SICEEP, DARLING SQUARE CONCEPT PROPOSAL S96– CONSOLIDATED AGENCY RESPONSE TO SUBMISSIONS

Figure 2.5 - Updated Parameter Plan Envelope Overlaid

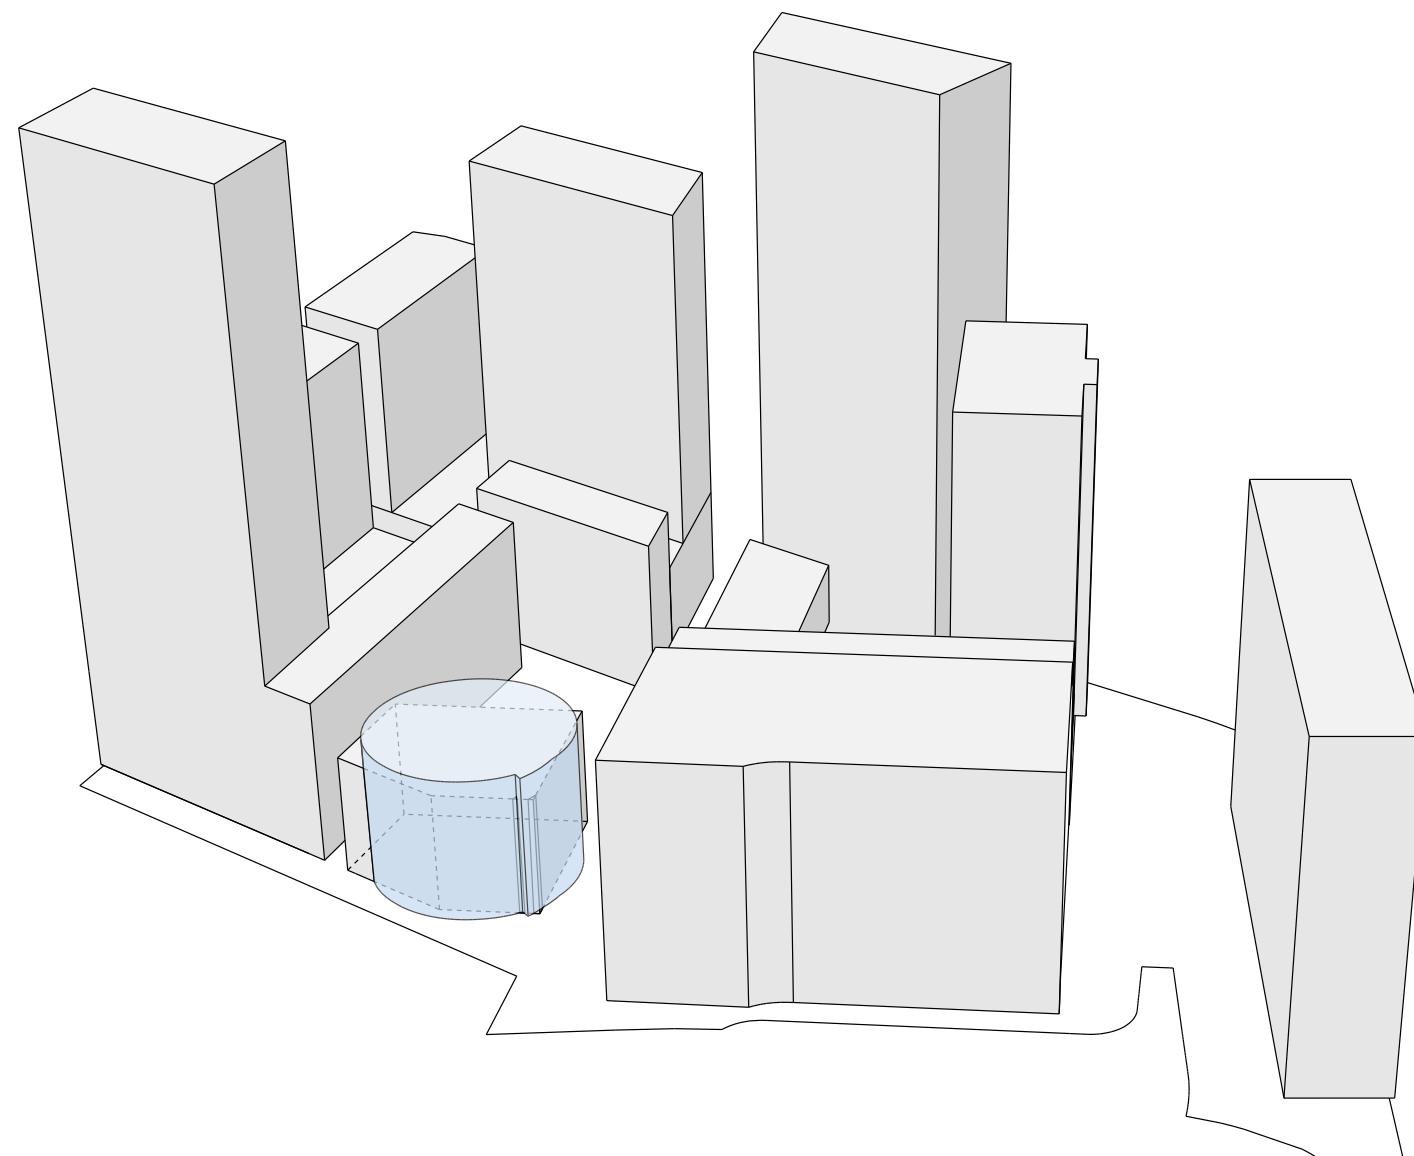
Confirm whether there will be a non-compliance between the proposed revised North Plot building envelope (i.e. overhang of the boulevard) and the 'Streets+ Lanes' controls of the Design Guidelines (i.e. street widths and openness to sky).	The 'Streets + Lanes' controls within the Design Guidelines (as updated) reflect the reimagined North Plot building. Specifically, the Design Guidelines now included for the reimagined North Plot building allows for encroachments into the Boulevard if key principles are still achieved. The detailed proposal for the North Plot building will be consistent with the Design Guidelines as the overhang is limited and will achieve the following requirements: ▪ not encroach into the Boulevard more than 1m at grade ▪ not block any view lines through streets and laneways ▪ maintain the tree alignment in the Boulevard Accordingly, subject to approval of the proposed amendments to the Design Guidelines there will be no non-compliance and the detailed DA for the North Plot Building (Darling Exchange) will also remain consistent with the Design Guidelines (as amended)

Parameter Plan 04: Drawing no MCD AR D205 Minimum building envelope separation

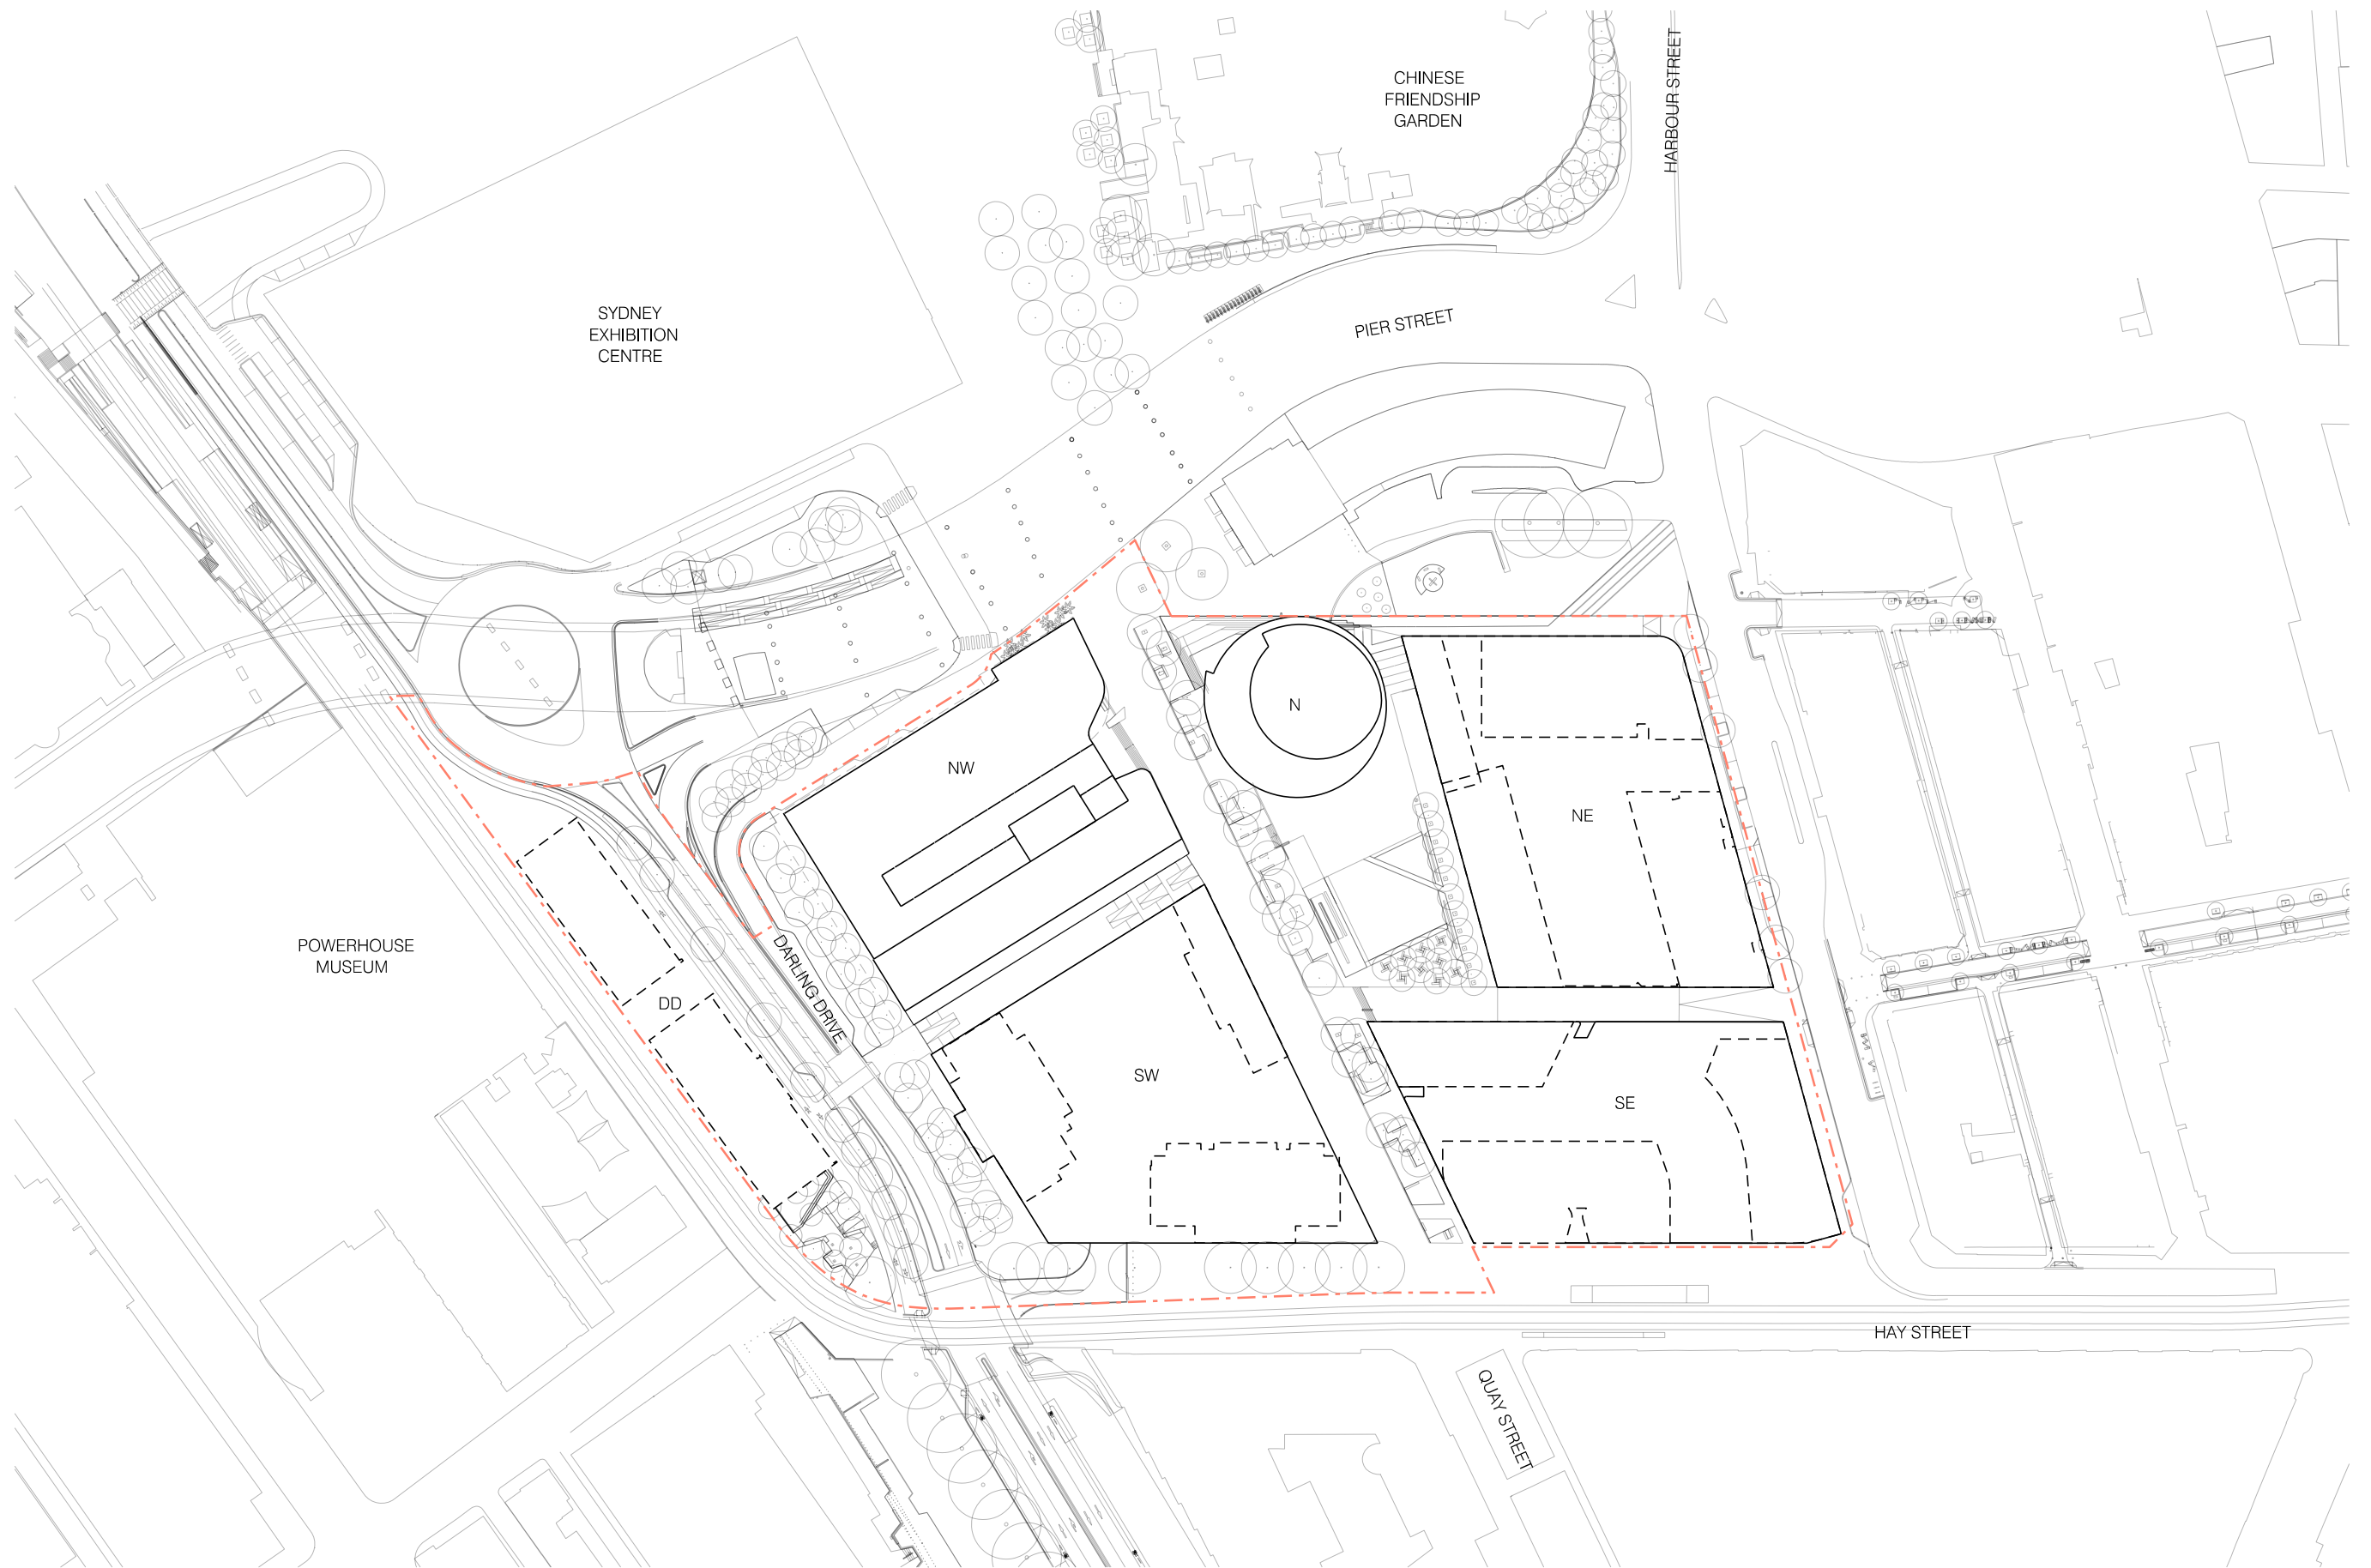
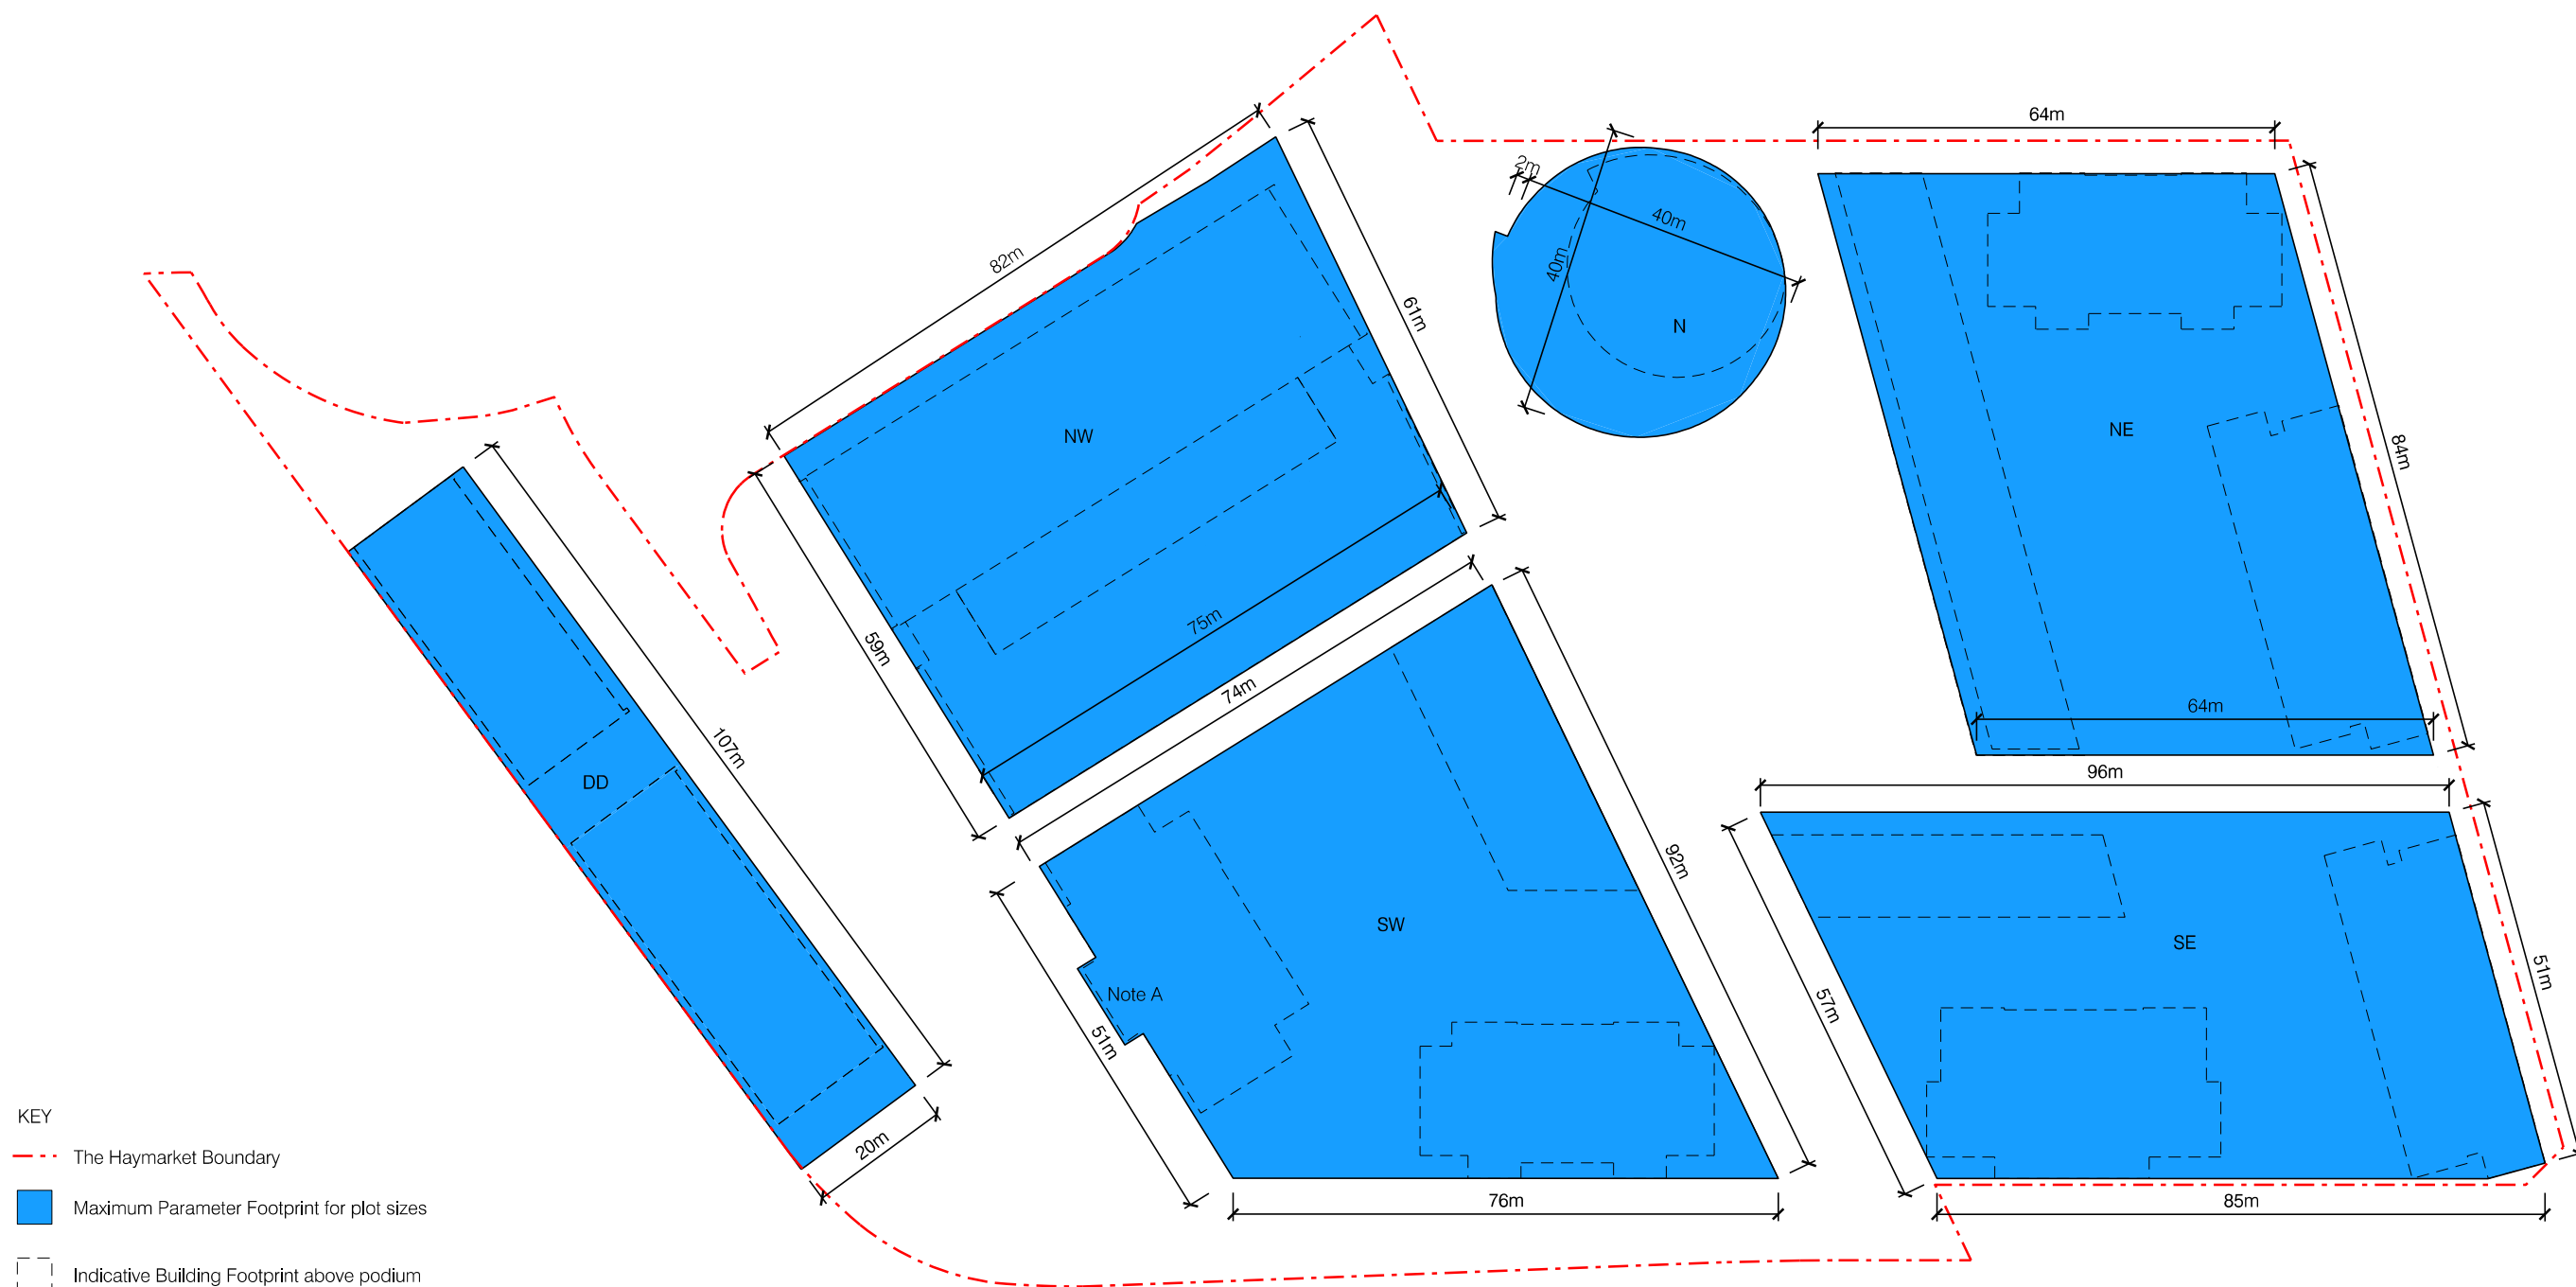
Key Issue	Response
City of Sydney Council	
Parameter Plans	
As was raised in the City's submission to the Stage 1 DA, the parameter block plans for the South-East Plot are substantially larger than the Stage 2 DA counterparts. The Stage 1 DA plans should reflect the Stage 2 DAs. There is no reason to bulk up the Stage 1 envelopes. This sets an expectation that envelopes may change in Stage 2 DAs or through later modifications, bringing with it increased environmental impacts.	The South East Plot is the sixth application progressed under the Darling Square Concept Proposal (SSD 13_5857), representing one of the final applications to be progressed in accordance with the Stage 1 Approval. The Concept Proposal established a maximum building envelope for each plot and an approved maximum GFA within the entire Darling Square development area. The built form of the South East Plot has been informed by the guiding approved Concept Proposal and is completely within the maximum building envelope established by the Concept Proposal and does not exceed the GFA for the Darling Square site (as proposed to be amended). A full assessment of the proposal's consistency with the approved Concept Proposal was provided with the exhibited EIS for the South East Plot. It was determined from this assessment that the South East Proposal is generally consistent with the approved Concept Proposal. No further change is proposed to the Parameter Plans beyond those outlined in the covering letter.
